Environment, Climate Change & Water

RE: Proposed modification to Woodlawn Wind Farm – Additional three wind turbine generators – s75W *Environmental Planning & Assessment Act 1979*

I refer to your letter dated 6 September 2010, and the attached Statement of Environmental Effects (SEE) for proposed modifications to the Woodlawn Wind Farm. It is understood that the proponent wishes to include an additional three wind turbine generators as part of the development and that this proposal is being assessed under the provisions of Part 3A of the *Environmental Planning & Assessment Act 1979*.

FIGURE 8.1: Heritage Sites

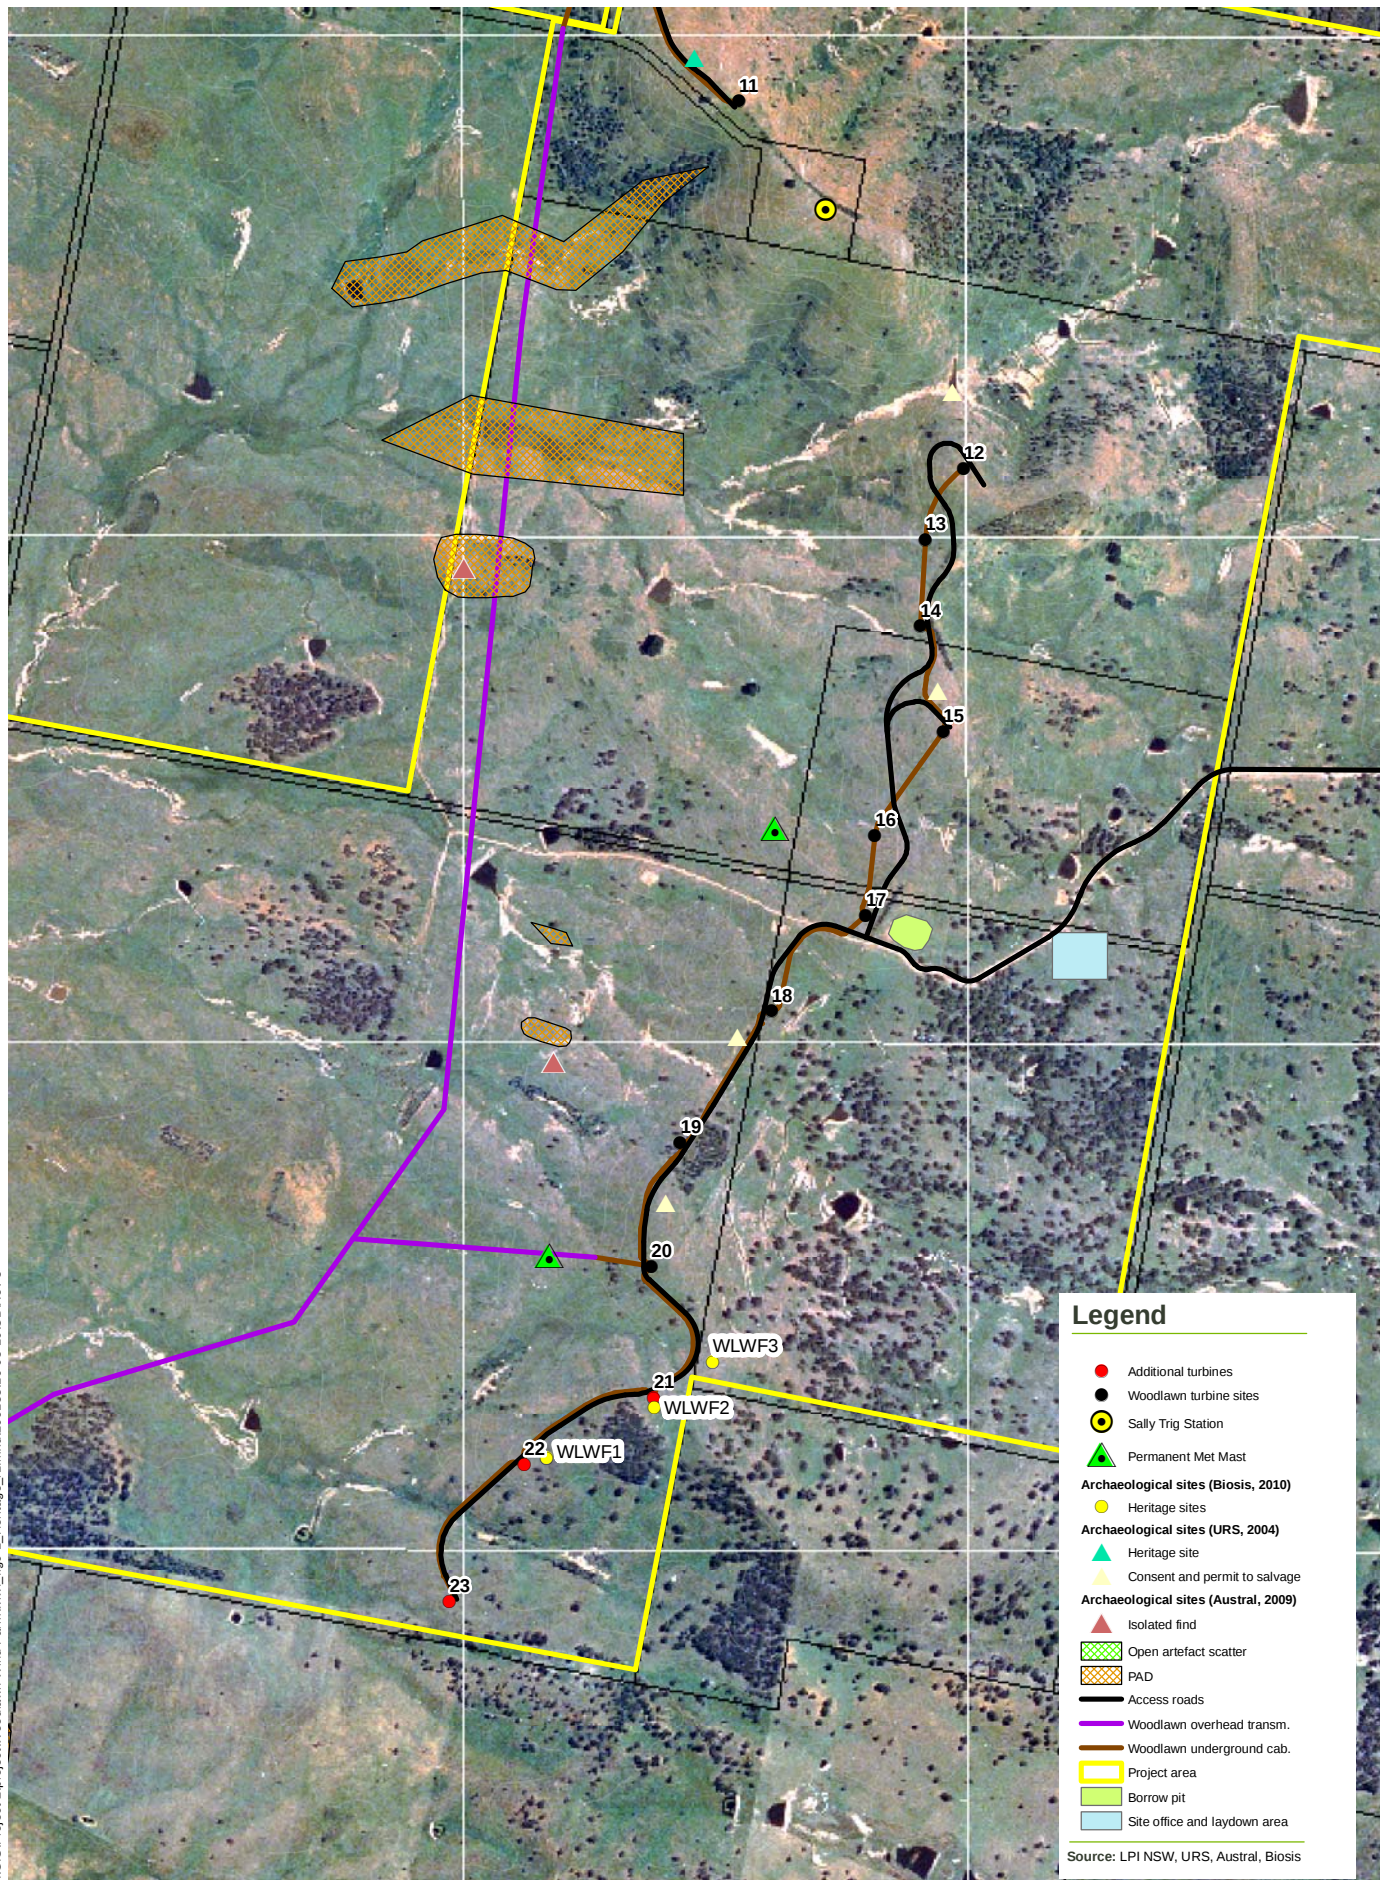
- Two sites where Aboriginal objects were found and may be impacted by the proposal were recorded during survey for the new turbine locations at Turbine 22 (site WLWF1) and Turbine 21 (site WLWF2).

- The identified sites all have low scientific and community significance except WLWF1 which has medium significance for Aboriginal stakeholder groups. DECCW would likely be able to issue an AHIP in respect of the sites. However DECCW understands that as this modification is being assessed as a Part 3A development, the proponent is exempt from requiring an AHIP.

- DECCW agrees with the recommendations in section 10.4.3 of the SEE which include the requirement that the Cultural Heritage Management Plan under the CEMP be amended accordingly by the proponent if this modification is approved, and fencing off of object sites be undertaken to avoid disturbance.
